Objection to a Proposed Mixed Use Development – 372-374 Mann Street and 35-37 Dwyer Street North Gosford

Your Ref: SSD – 69773460

Department of Planning, Housing and Infrastructure

View Impact Analysis

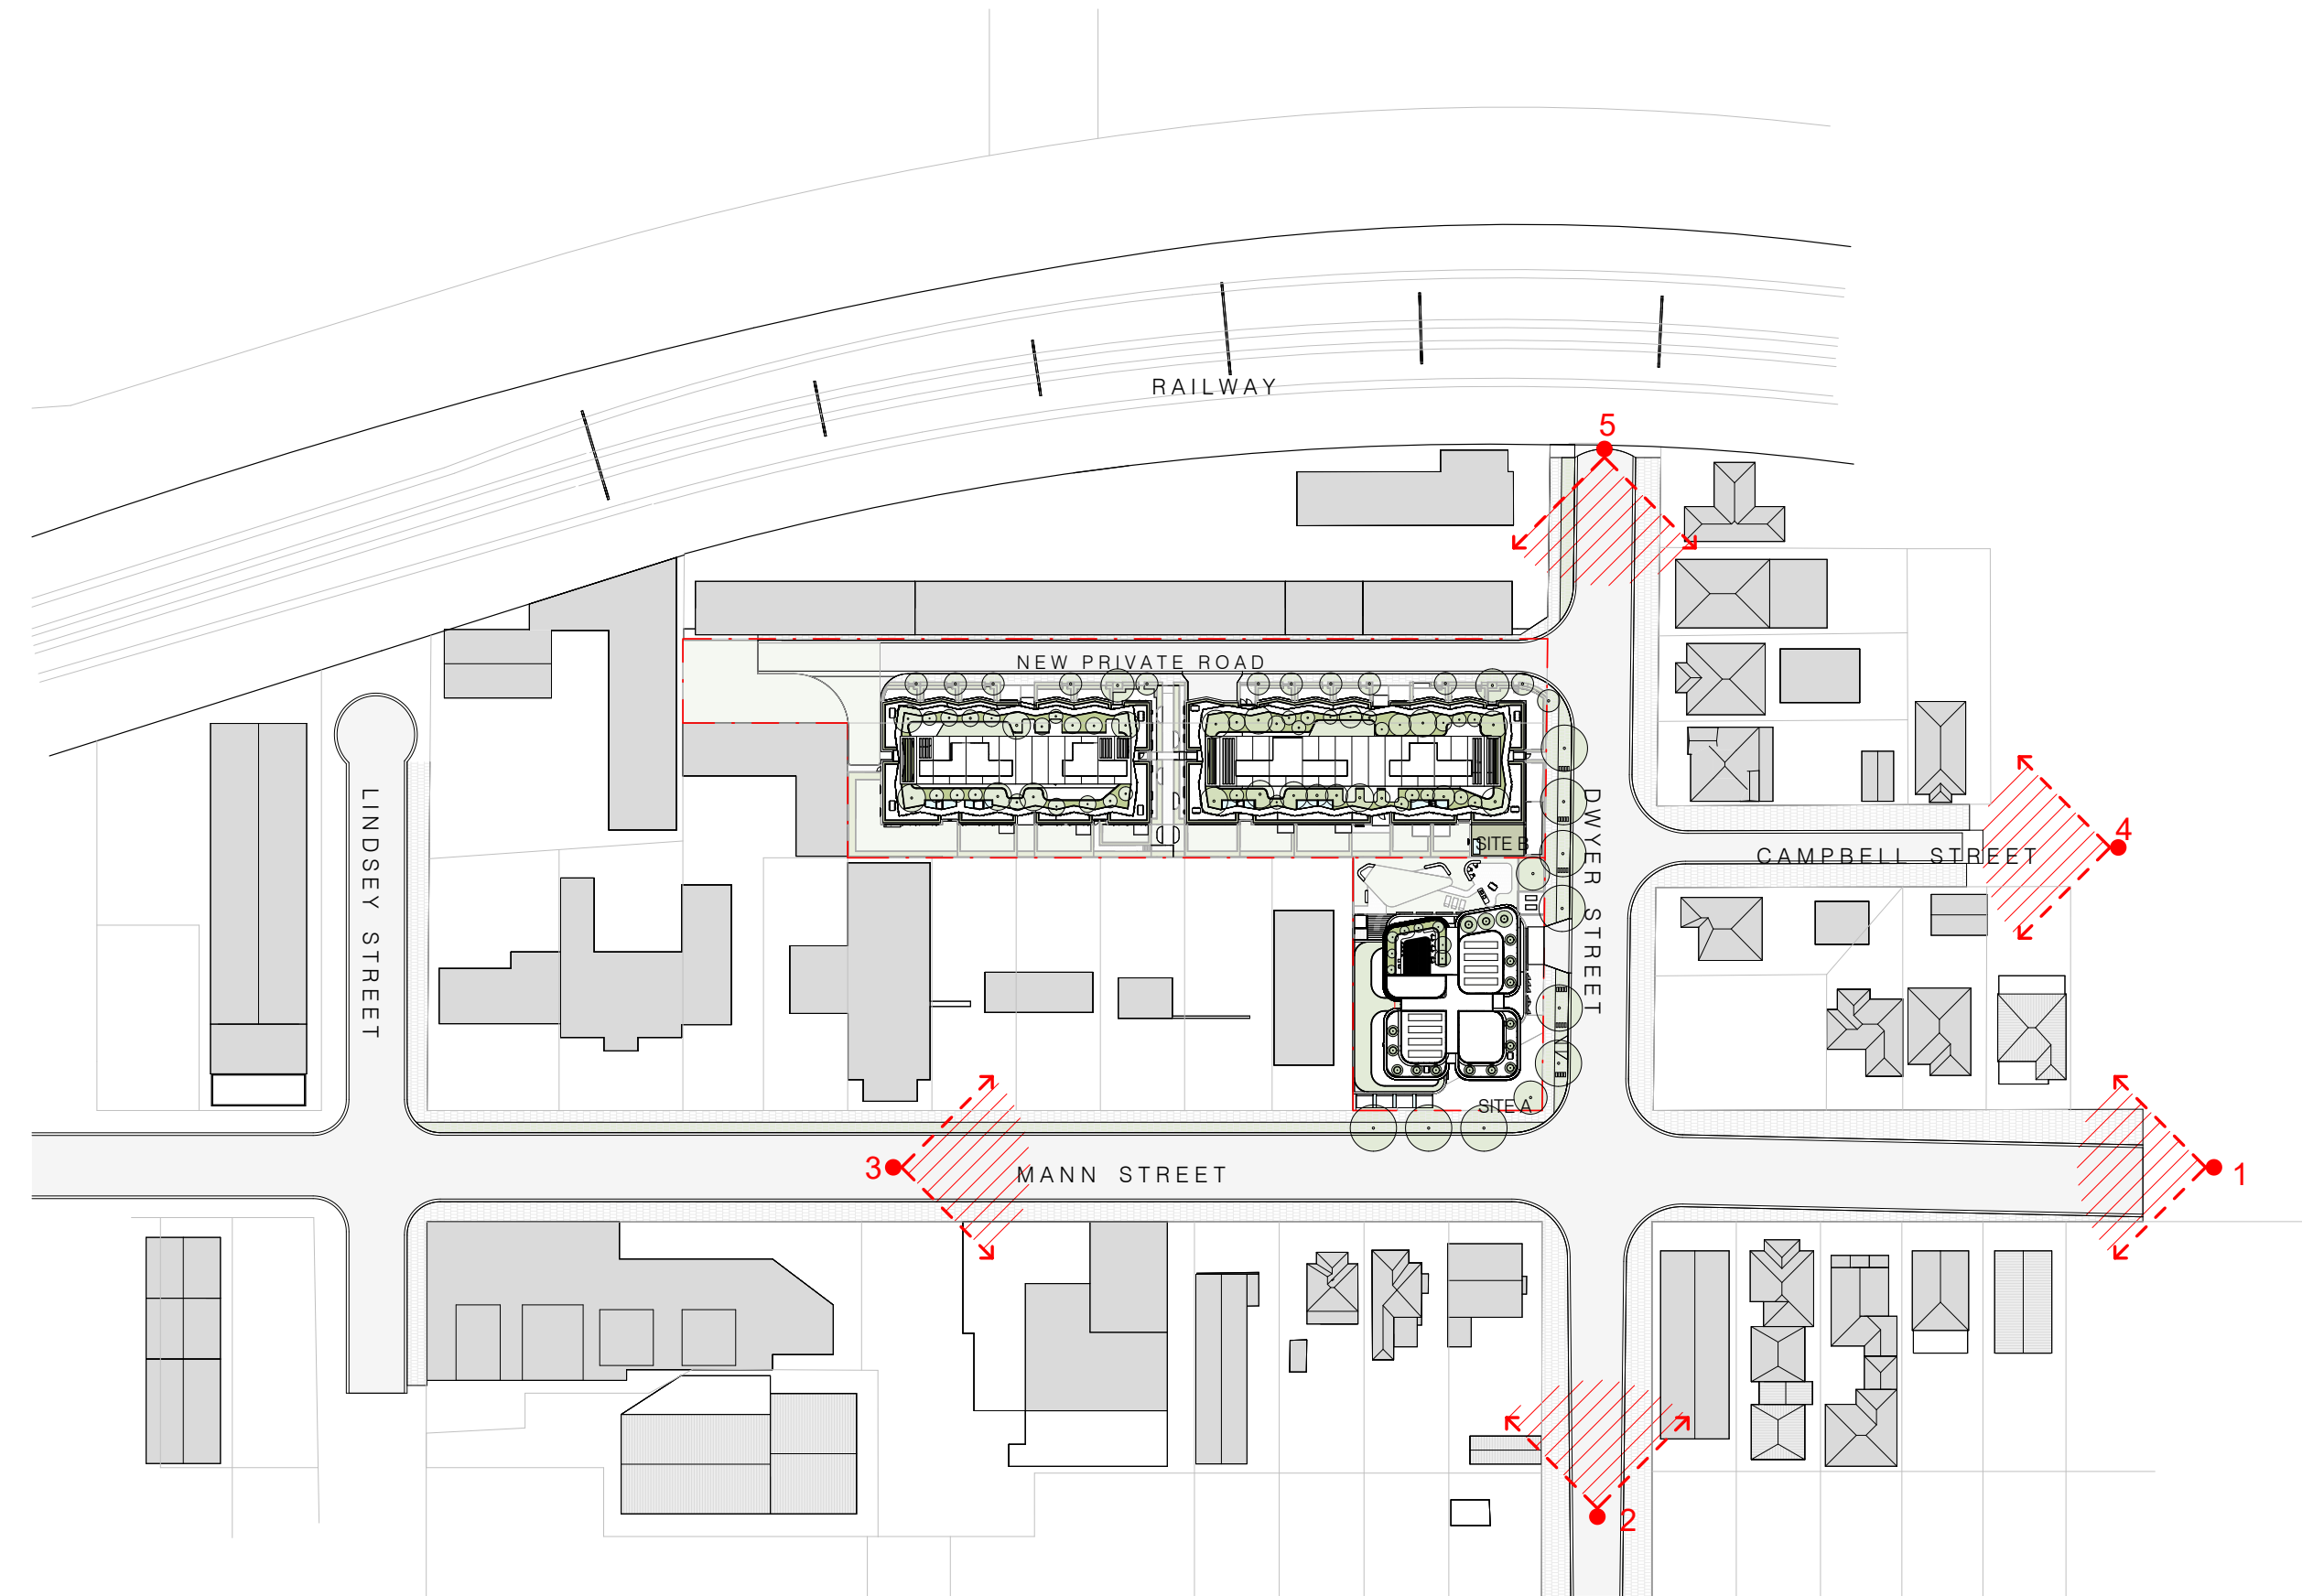
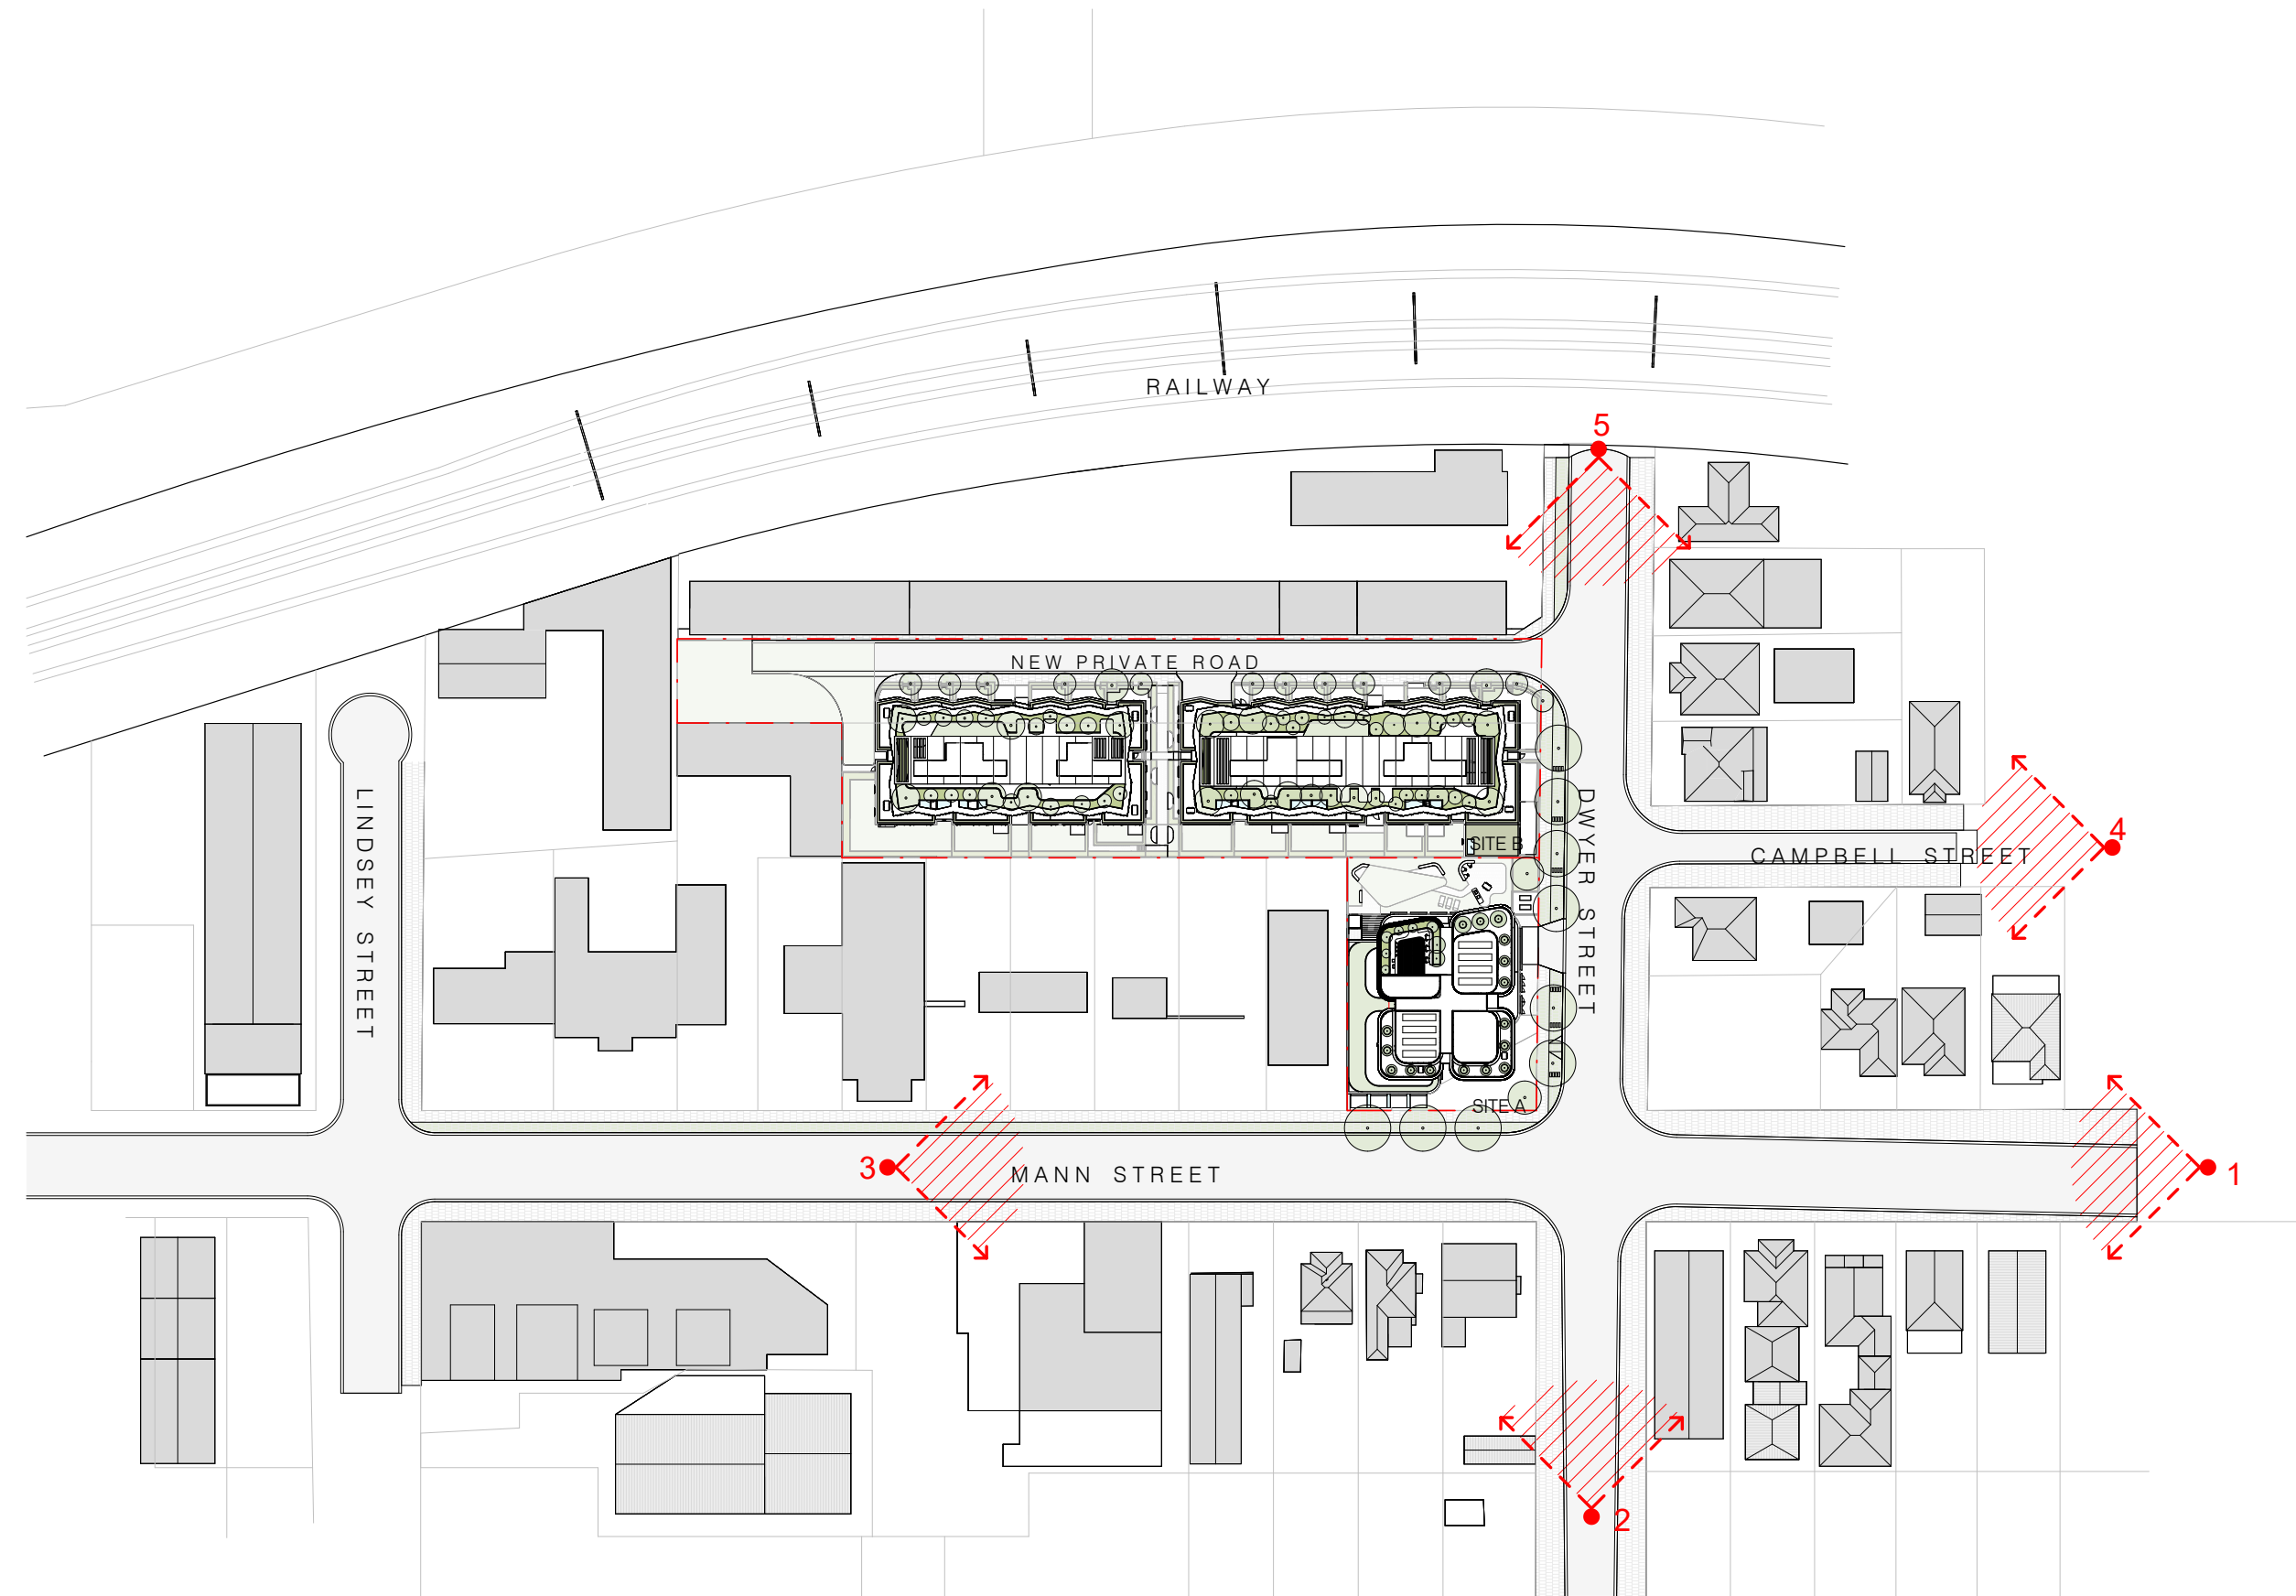
- The proposed tower and apartment buildings at the rear will completely block our existing view of the Gosford Showgrounds. The Gosford Showgrounds is an iconic location within Gosford and it is a view which we have very much enjoyed whether it is watching the greyhounds, fireworks, monster trucks or go kart racing there is always something worth watching at the showgrounds. This development will erase 100% of our view. There has been no mention of the impact on views from the buildings situated higher than this site in any of the planning documentation submitted. In fact the documentation is completely disingenuous as it assumes the surrounding area is already developed through the use of artistic representations to show surrounding development as large scale residential apartment buildings which simply don't exist. They have looked at an imaginary scenario rather than the real situation;

- Tenacity Consulting Vs Warringah Council established the test and planning principles for view sharing. This includes a four step process with the first step prioritising the views i.e. iconic views or water views are the most prized. I would argue that that views of the showground are absolutely iconic in the context of the Gosford landscape and that the construction of the oversized tower and buildings on Site B will completely obliterate any view that we have. The second test states that views from living areas are the most prized. Our views of the showground and surrounding treed mountains are from our living room so they should be given some priority in terms of view sharing. The third test is the severity of the view loss. We will lose quite a large chunk of our distant views of the mountains and 100% of our views of

the showground. The severity is at a maximum level. No effort has been made by the developer at all to ameliorate the loss of views from existing adjoining dwellings. If the buildings on Site B were to be constructed to the permissible height limit and perhaps divided into 3 x buildings with no access road (so as the same density can be achieved) then there could potentially be some sharing of views. As mentioned, they have created a make believe situation where everything surrounding the development is already constructed at a high density;
